Please ask for: Nicola Moore
Email: nicola.moore@arun.gov.uk
Telephone: Ext 37944
Our Ref: BN/15/21/CLP
Your Ref:
Date: 2nd March 2021

Lawful Development Certificate for a Proposed Use or Development

Development: Lawful development certificate for the proposed use of existing cabin ancillary to house for private use and short term lets.
Location: 58 Downview Road Barnham PO22 0EF

FLOOR PLAN

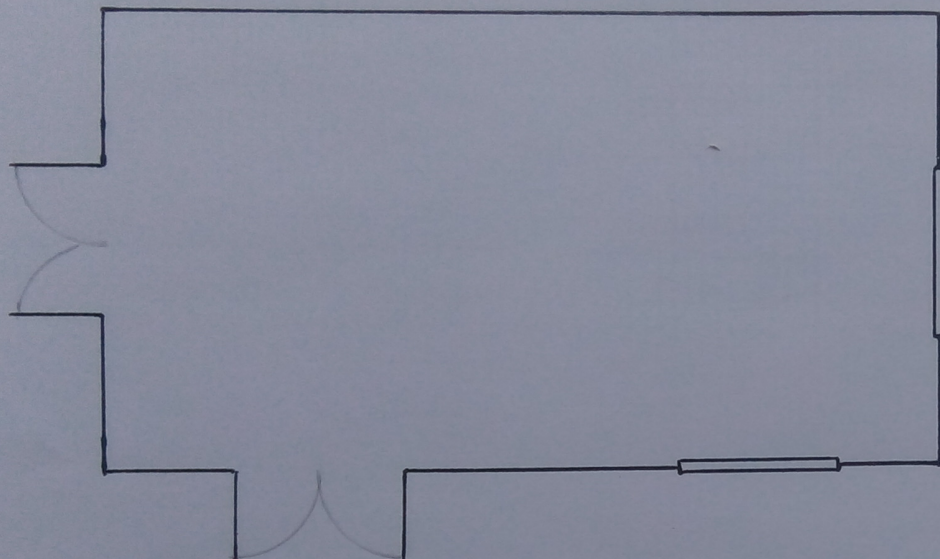
The submitted Proposed Floor Plan shows 2 doors (front & side) from the open space living room. However, the proposed elevation only shows 1 (front elevation). Please amend accordingly and re submit.
